State Significant Development Application – SSD-81434988
221-235 Luddenham Road, Orchard Hills
Alspec Warehousing Facility

17 September 2025

Sydney Metro has reviewed the Environmental Impact Statement including Appendix E - Mitigation Measures Table, Appendix P - Construction Traffic Management Plan and Appendix HH - Traffic Impact Assessment and provide the following comments and recommendations for consideration by DPHI in relation to the assessment of the SSD.

Figure 3-4 Construction traffic flow during Sydney Metro off peak periods

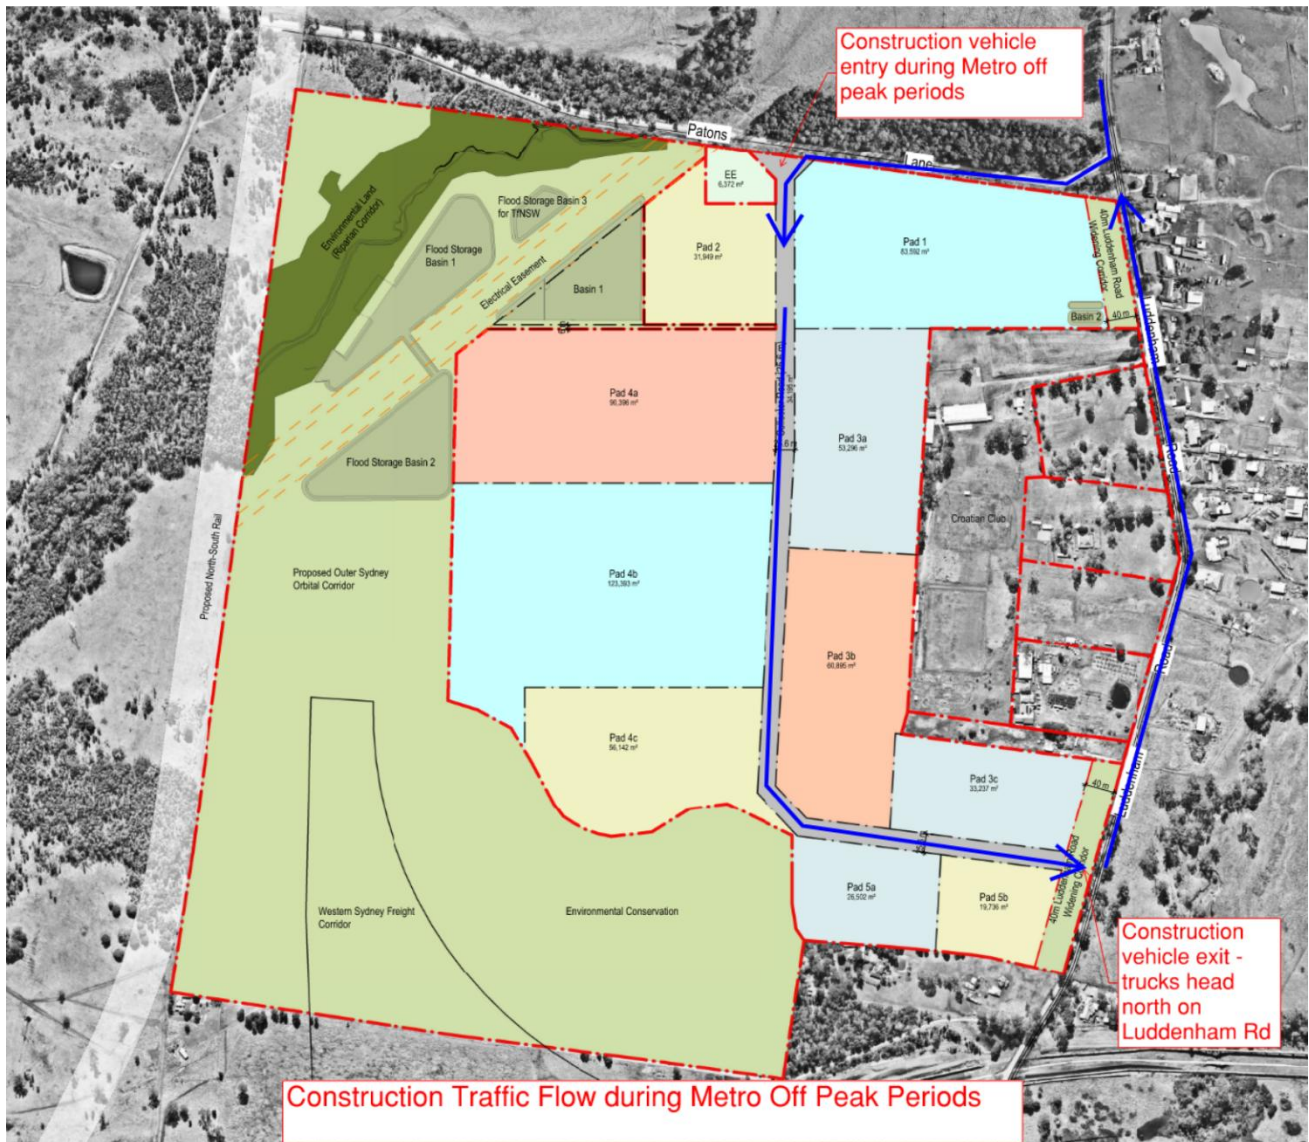
The Sydney Metro preferred option is Figure 3-4, where during ‘Sydney Metro off peak’ periods construction vehicles will revert to the one-way loop arrangement, that is to enter via Patons Lane and exit via the southern access off Luddenham Road. This will reduce vehicular movements on Patons Lane by allow vehicles to exit directly onto Luddenham Road. This vehicle movement is shown in Figure 3-4.

Figure 3-6 Indicative AIBP construction timeline

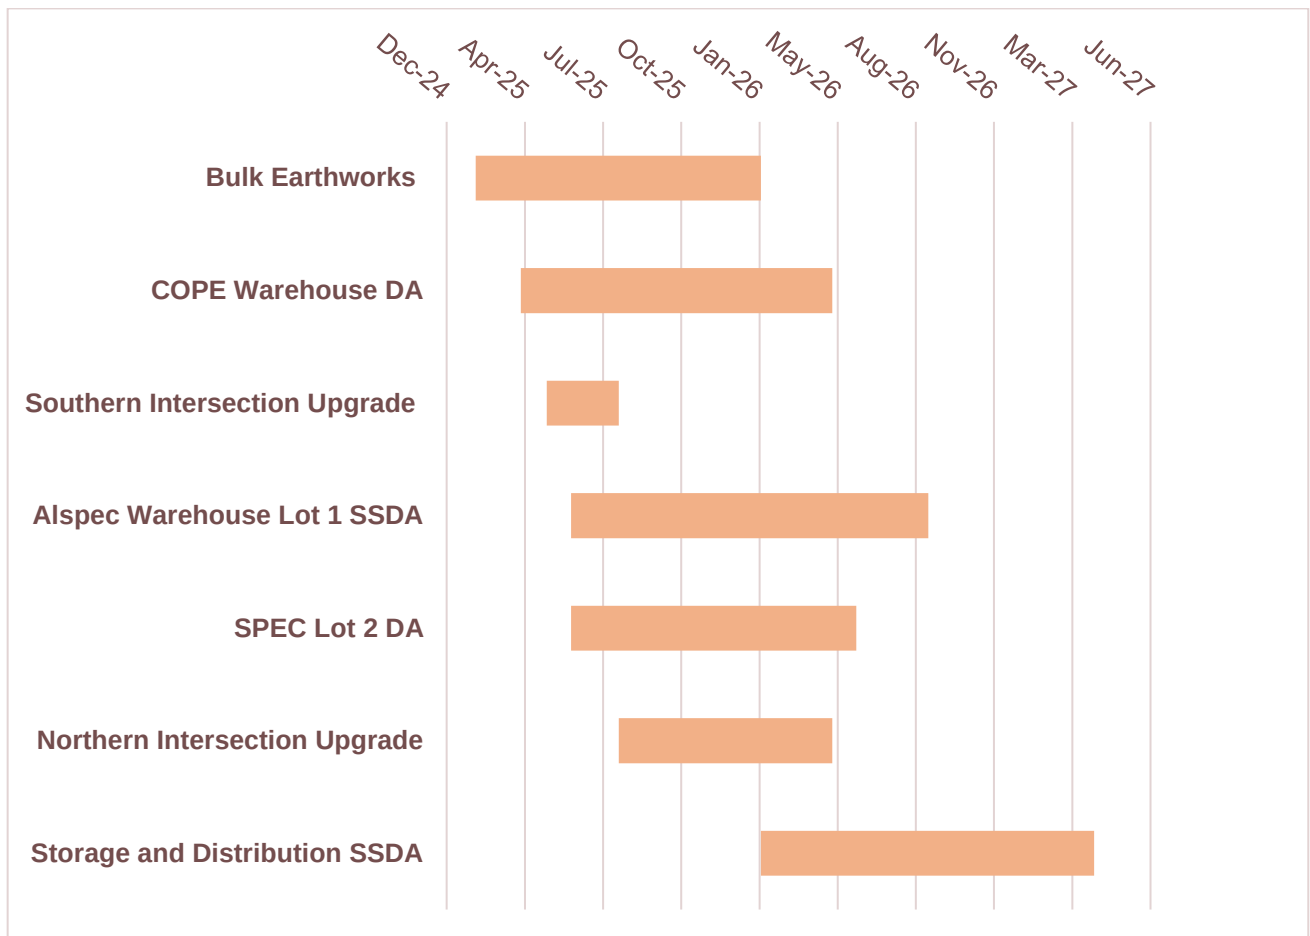
Comment: Figure 3-6 – Indicative AIBP Construction Timeline outlines the proposed construction schedule. However, the indicative dates for the Southern and Northern Intersection Upgrades appear to require updating. It is important that these dates are revised to ensure Sydney Metro has an accurate understanding of AIBP’s peak construction period and its potential impact or overlap with the construction and delivery timelines for Sydney Metro’s rolling stock.
